Subject: **Request for a Nationwide 23 Permit Modification** for the Replacement of Bridge No. 26 over Deep Creek on SR 1154, Carteret County, Federal Aid Project No. BRSTP-1154(2); State Project No. 8.2161001; TIP No. B-3626.

This modification addresses a Special Sediment Control Fence not described in the previous application.

CLEARING AND GRUBBING EROSION CONTROL FOR CONSTRUCTION SHEET 4

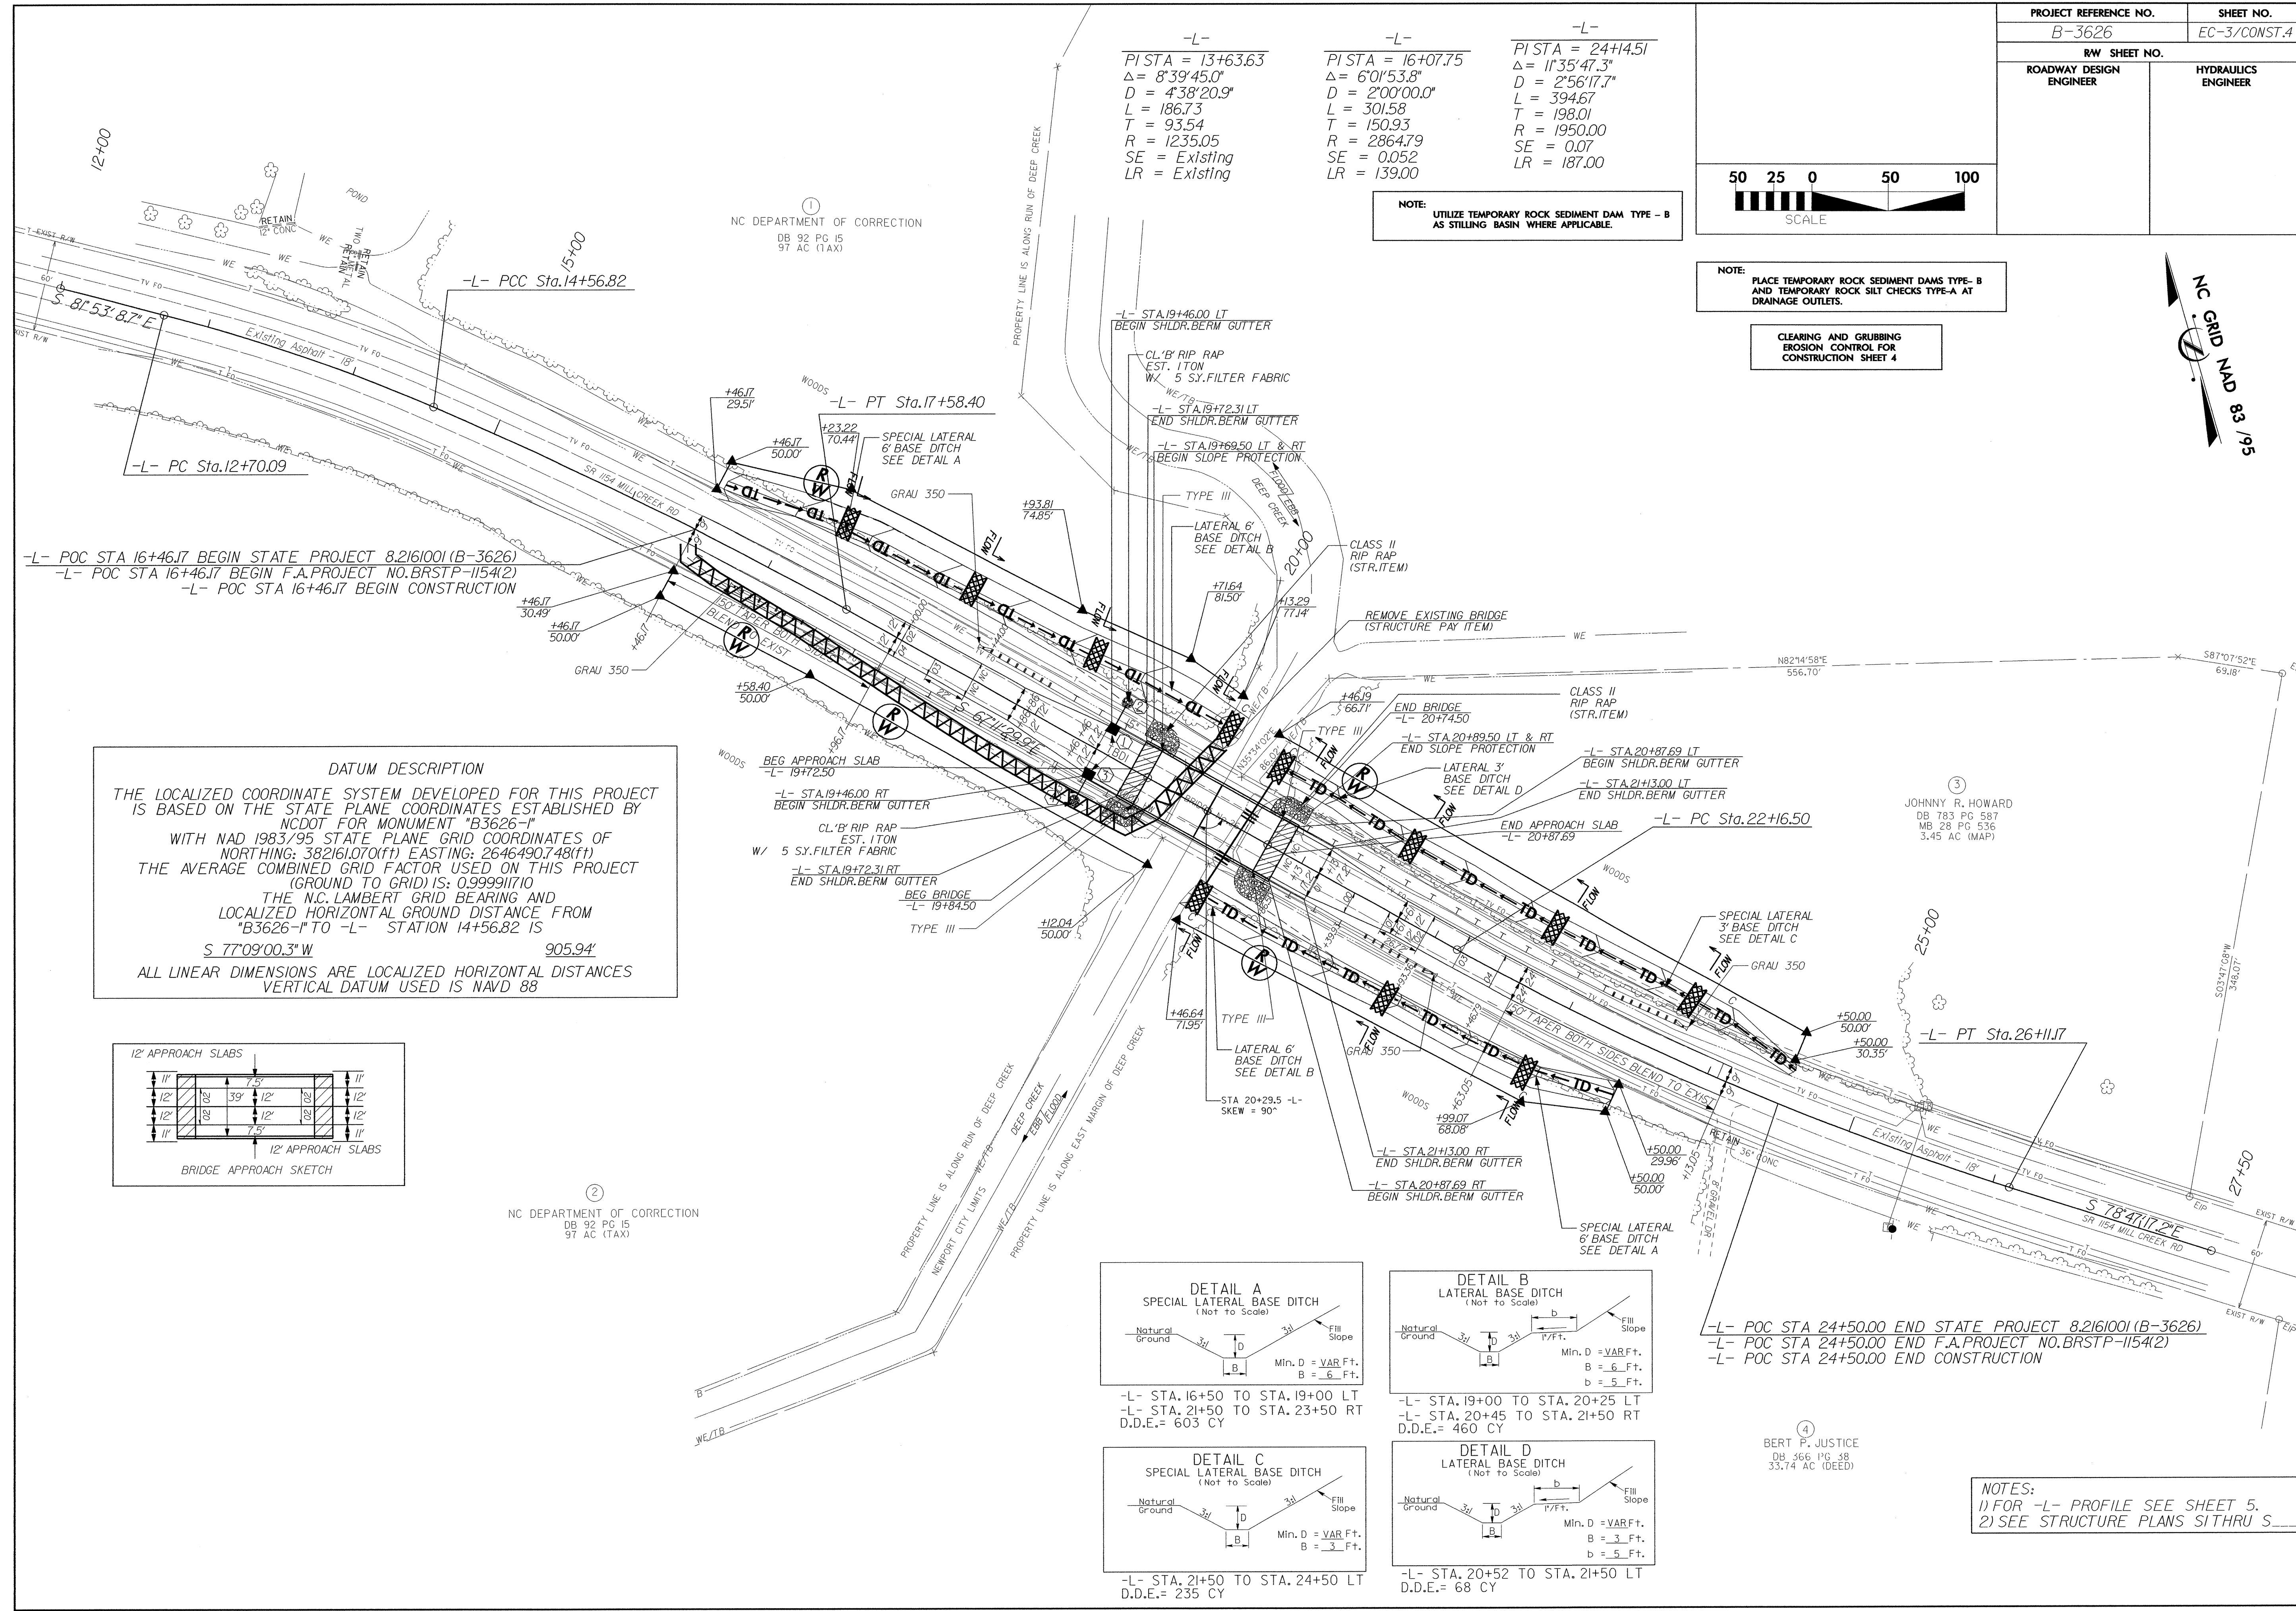
The Special Sediment Control Fence has been designed to withstand tidal fluctuations that occur in the area, and will be placed in the area designated as "mechanized clearing in wetlands" as shown in the attached drawings. This fence consists of ¼ wire mesh secured on #57 class stone. The footprint of the stone (temporary fill) will be 2 feet wide and 1 foot tall, totaling 700 ft<sup>2</sup> (0.02 acres). The entire Special Sediment Control Fence configuration will be placed on hardware cloth to allow for easier removal.

The Special Sediment Control Fence will be installed approximately 5 feet from the slope stake line right of L- from Sta. 16+46 to Sta. 19+96.
